**WELWYN HATFIELD BOROUGH COUNCIL – DEVELOPMENT MANAGEMENT
DELEGATED REPORT**

APPLICATION No:	N6/2013/0728/FP
APPLICATION Site:	8 Rooks Hill, WGC

DESCRIPTION OF PROPOSAL: Erection of part single and part two storey rear extension and new window to flank elevation

Drg.No: AT442-06

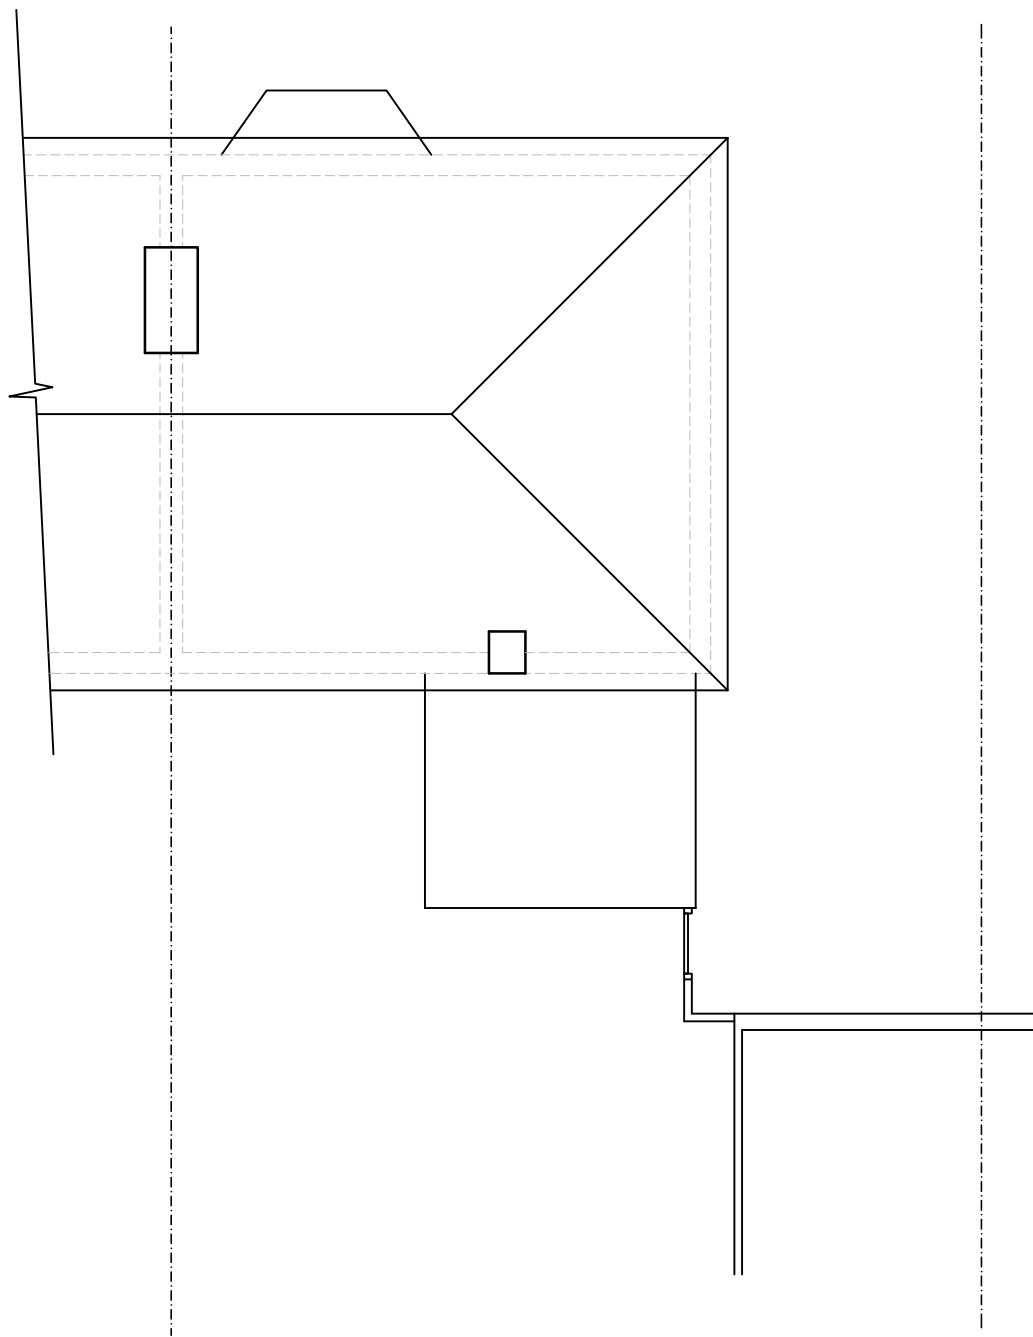
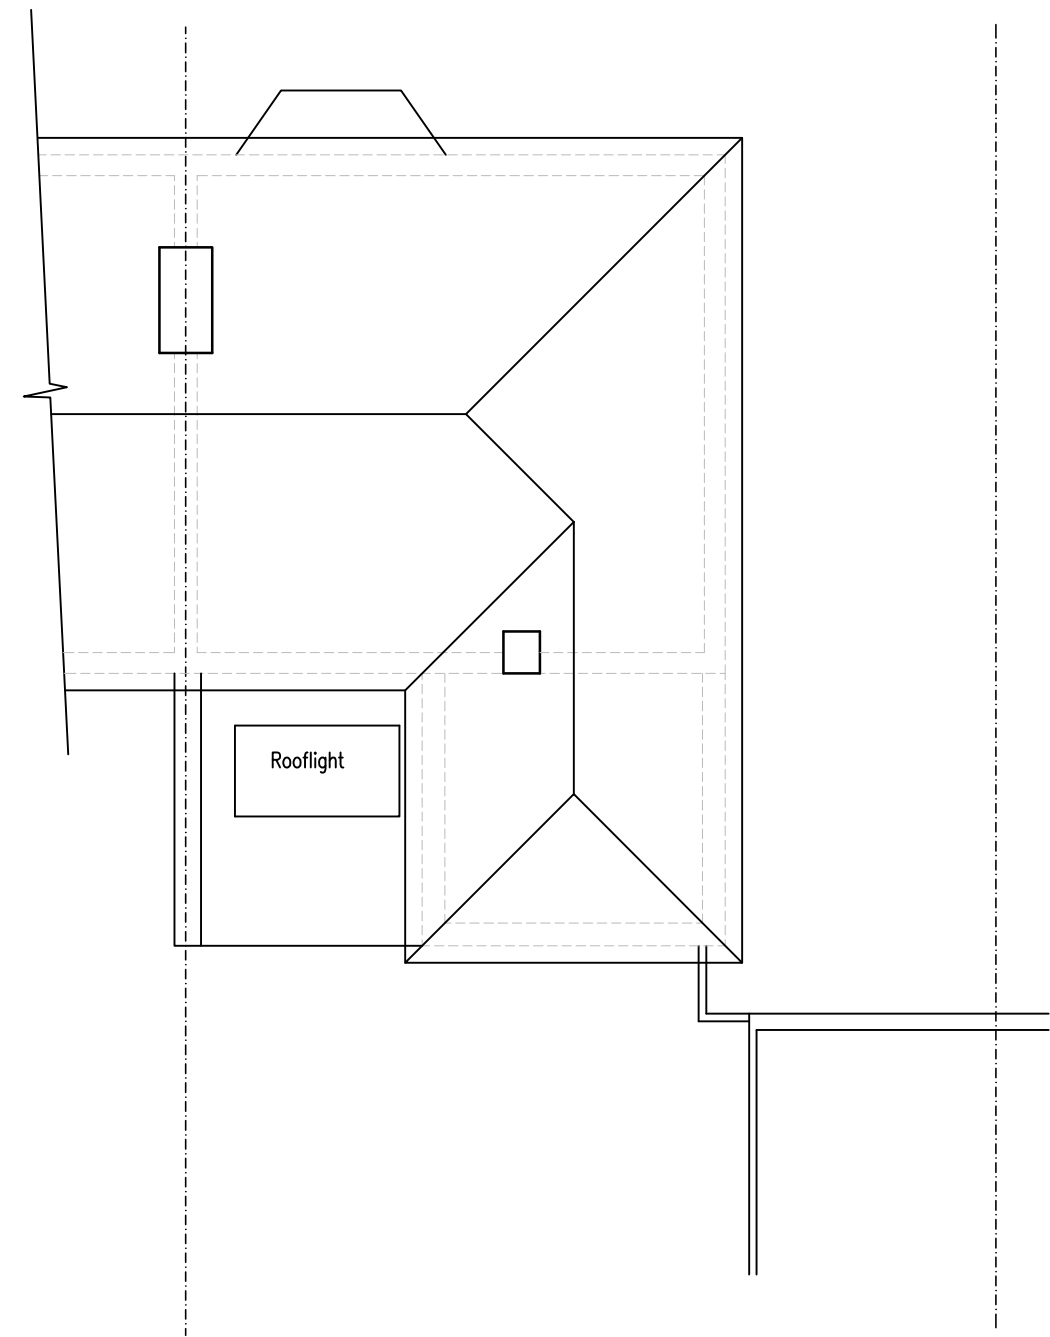
The proposal is to extend the property to the rear to a depth of 3.6m to create a kitchen and lounge area. This will extend to the full width of the existing property and will be flush with the existing side wall of the dwelling. Above part of the single storey extension will be a first floor extension creating a larger bedroom which will be to the same depth and will have a width of approximately 4m. Above this a flat roof is proposed over the single storey rear extension and a hipped pitch roof over the first floor which will be flush with the current hip of the main roof with a ridgeline which is stepped down.

Drg.No: AT442-05

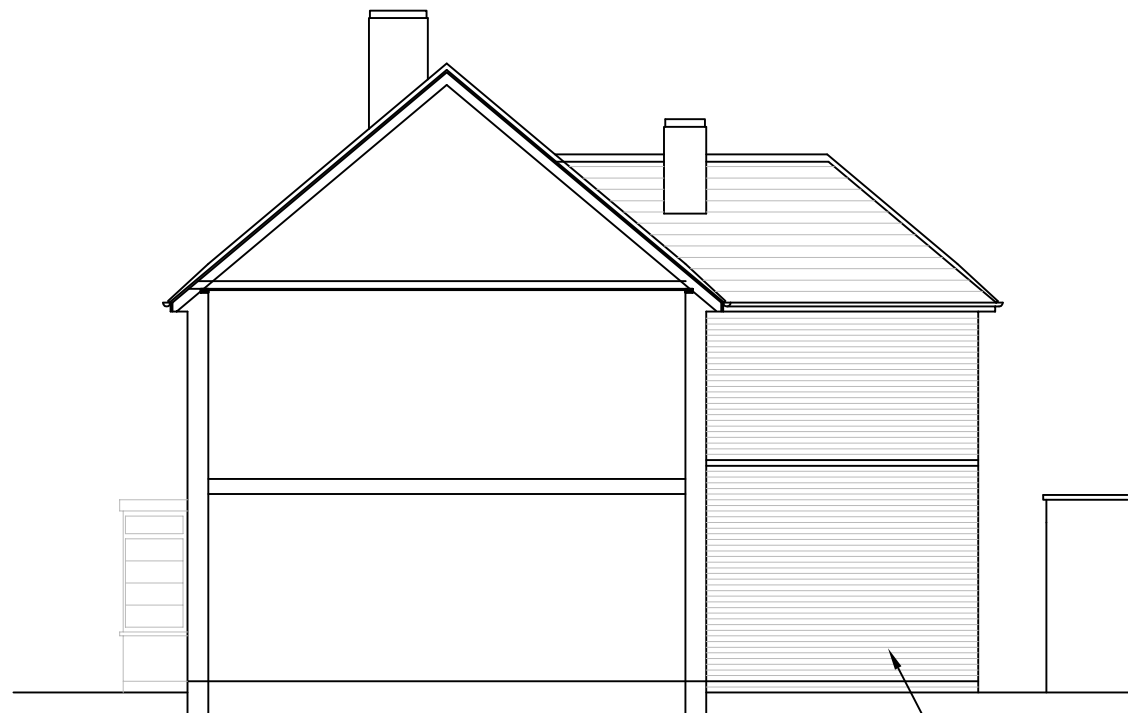
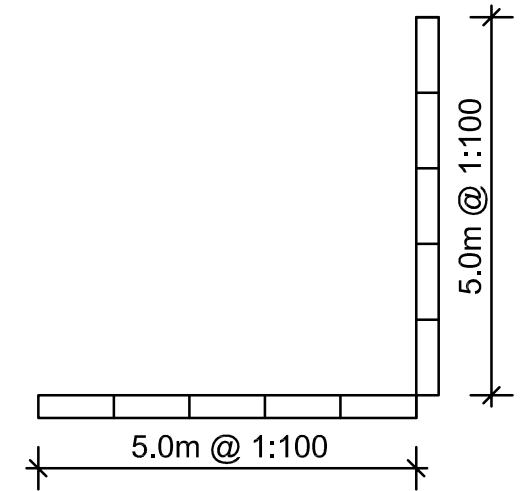
In regards to No.6, a proposed party wall is proposed at ground floor level. The depth of this new flank wall and height are considered not to appear overly dominant or over bearing to this neighbour as the scale of this wall is reasonable in this location. No side windows are proposed and so there will be no direct overlooking. Although there will be some overshadowing from the new flank wall during the first part of the day, this will not be so significant as to be harmful to the residential amenity of No.6.

There is a new side window proposed at first floor level to serve the enlarged bedroom which is shown obscure glazed and non-opening below 1.7m for floor level. A planning condition to ensure this requirement is reasonable to avoid any potential overlooking to this adjoining neighbour.

3. C.5.1 Sample of Materials
4. The proposed first floor side to the new bedroom of the proposed building shall be glazed with obscured glass and shall be fixed so as to be incapable of being opened below a height of 1.8 metres above floor level, and shall be retained in that form thereafter.

Drg.No: AT442-04

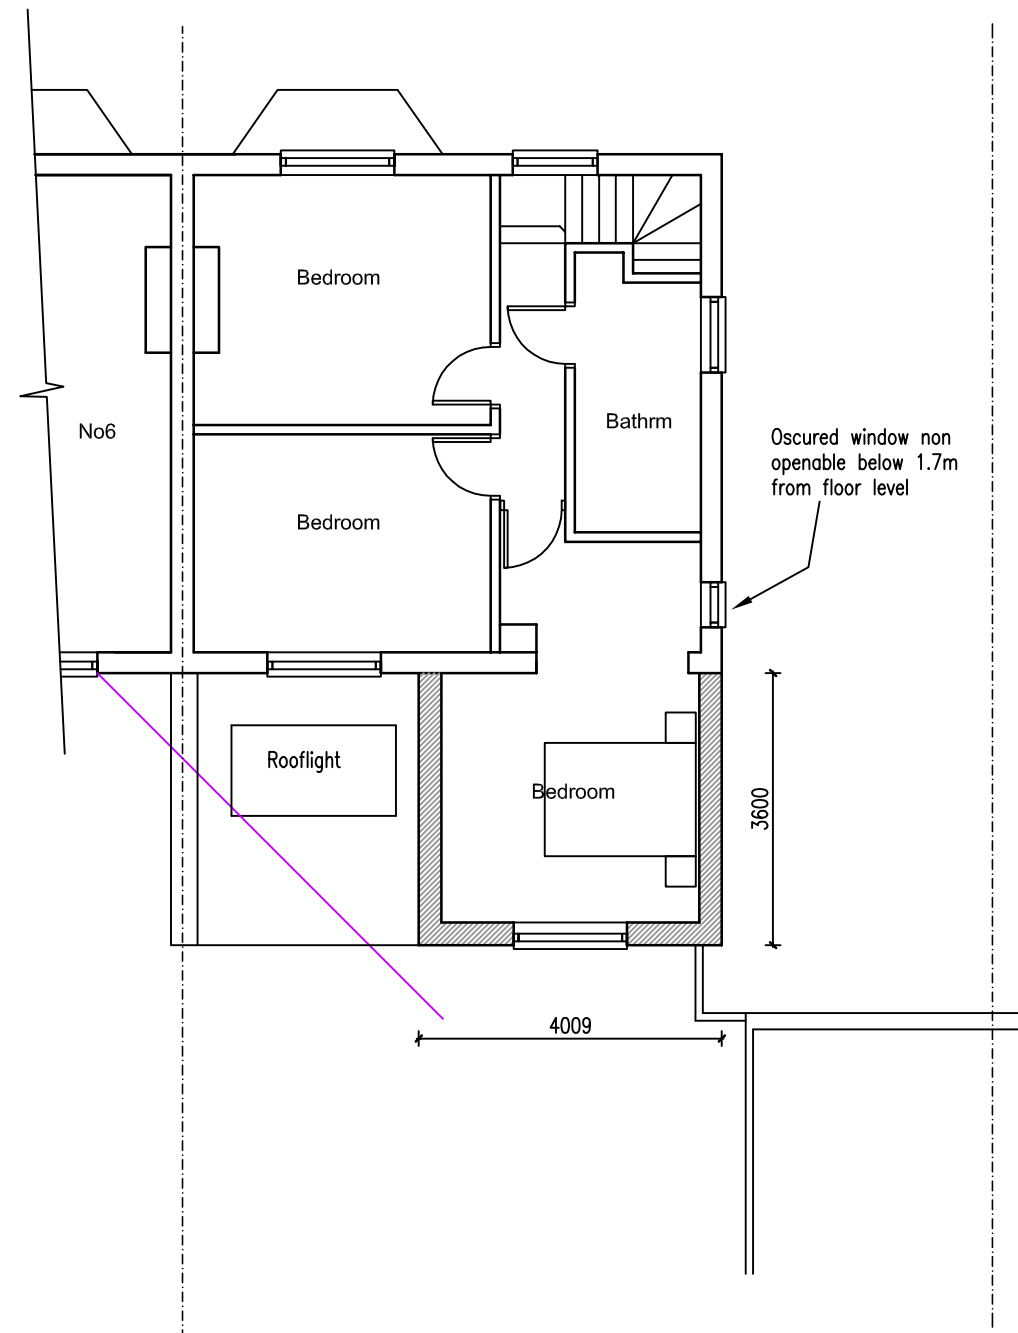
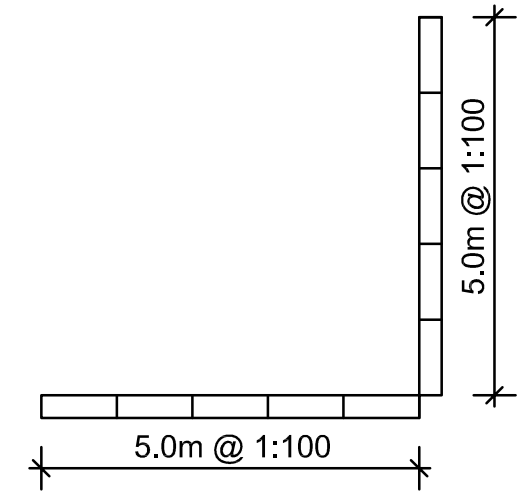
At first floor level the proposed extension is set back sufficiently from the common boundary with this neighbour to ensure that it will not harm the outlook of this neighbour's rear first floor window in terms of sunlight/daylight or from the extension appearing over dominant.
